From: Clare Dales
Sent: 09 April 2018 10:39
To: Andrew Wood
Subject: RE: Planning Consultation on: AW/45/18/HH

APPLICATION **AW/45/18/HH**

Site Address: 19 Kingsway Craigweil Aldwick PO21 3JX

Description of Works: Rear single storey & two storey extensions, front single storey extension & canopy roof plus alterations to external wall & roof finishes. This application affects the character and appearance of the Craigweil House, Aldwick Conservation area

sheet 3 of 5

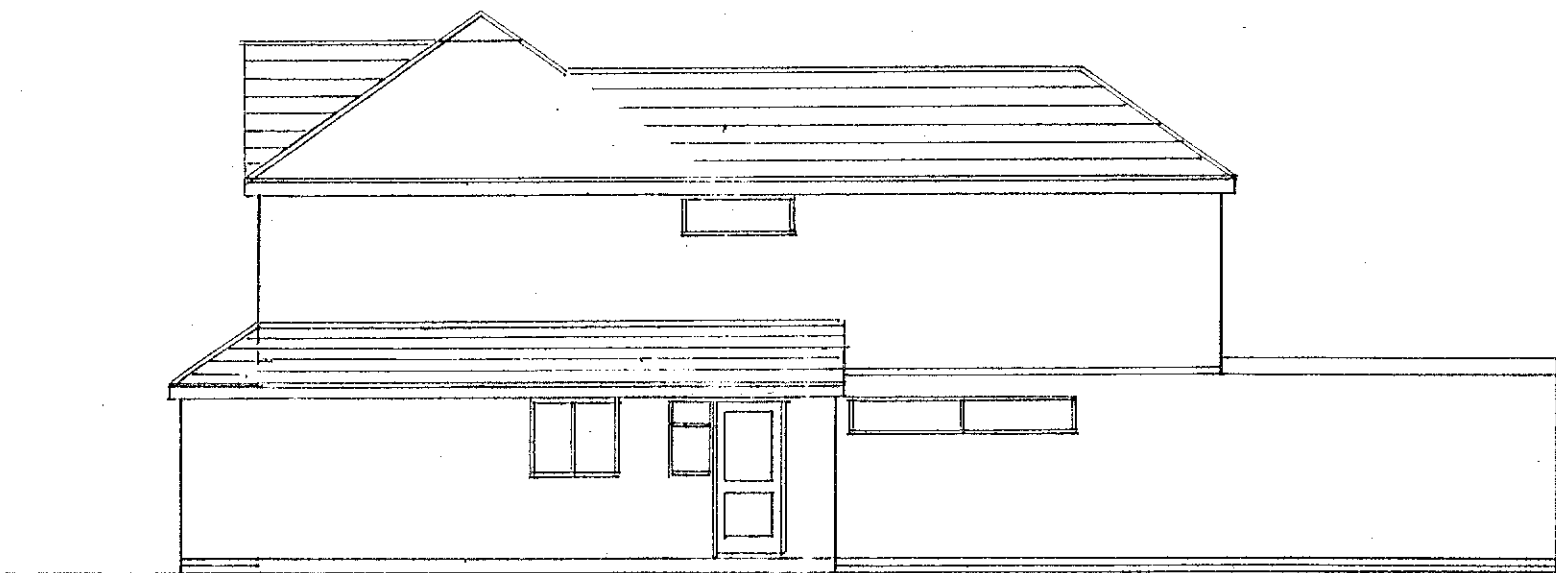
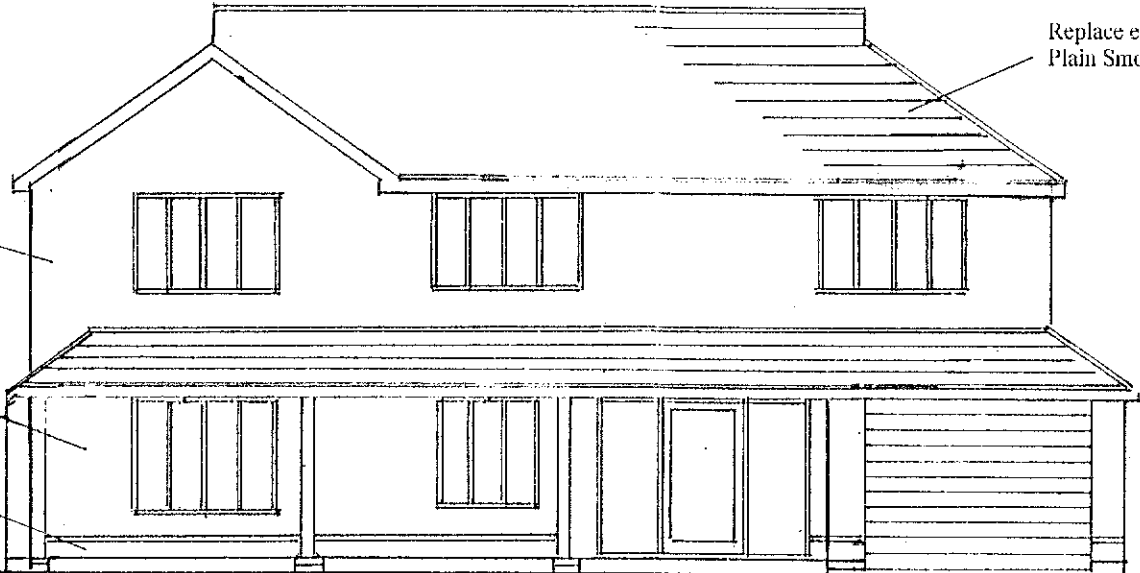
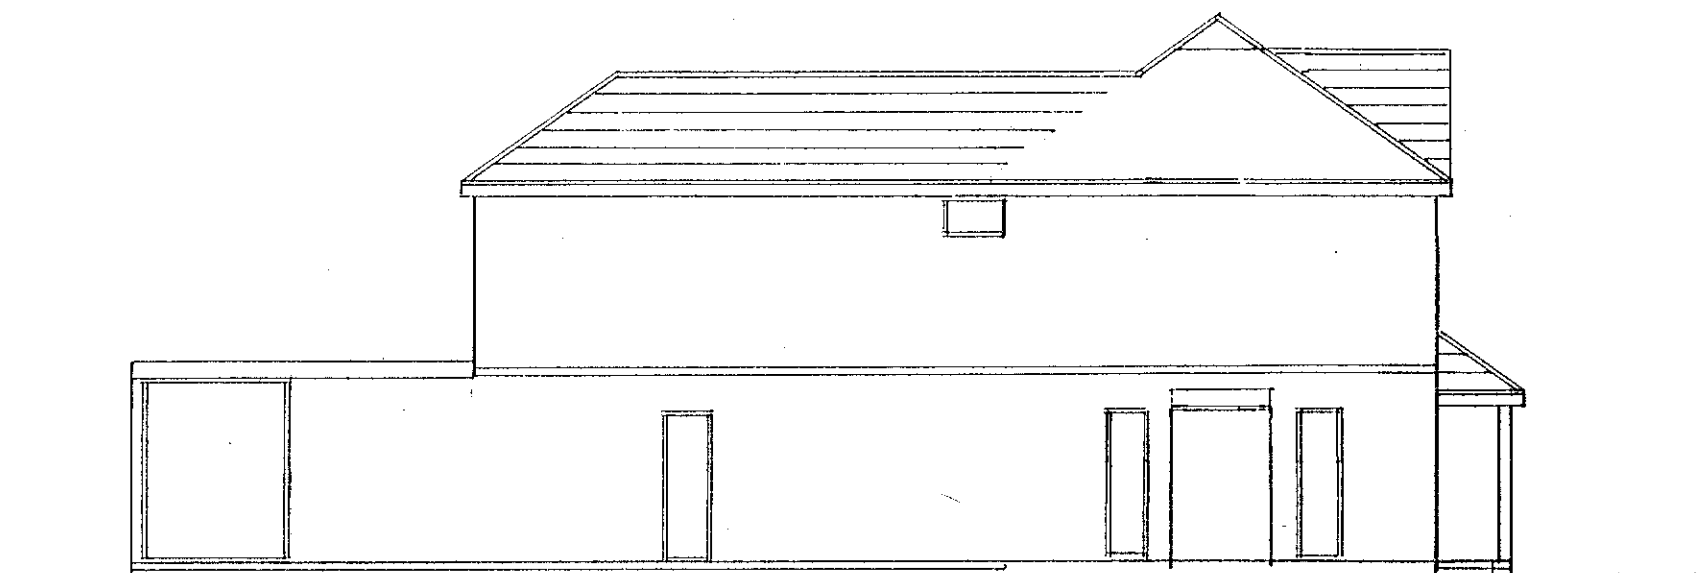
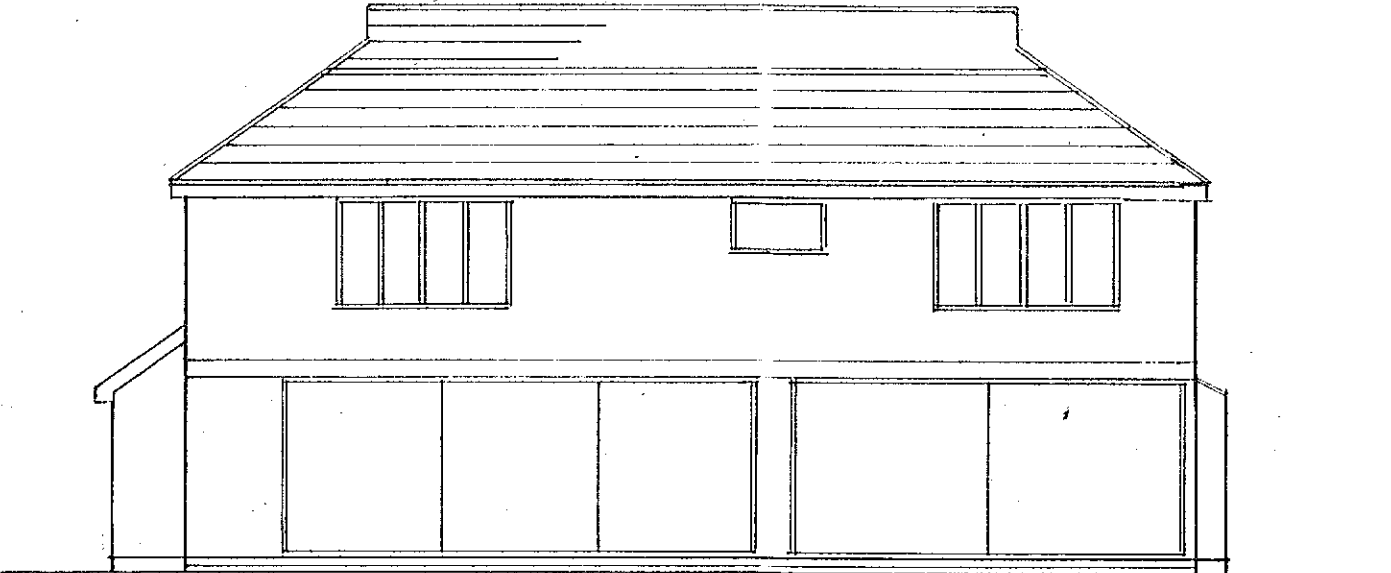
The submitted plans show a dwelling which is significantly larger than the host dwelling, and somewhat subsumes it. The proposed roof line obscures the host dwelling, as does the proposed deep veranda-style frontage. It is considered that the proposed is dominant in its setting, and would affect the setting of the adjacent building, which is on the List of Buildings and Structures of Local Interest, and impinges on the intended visual gap between buildings.
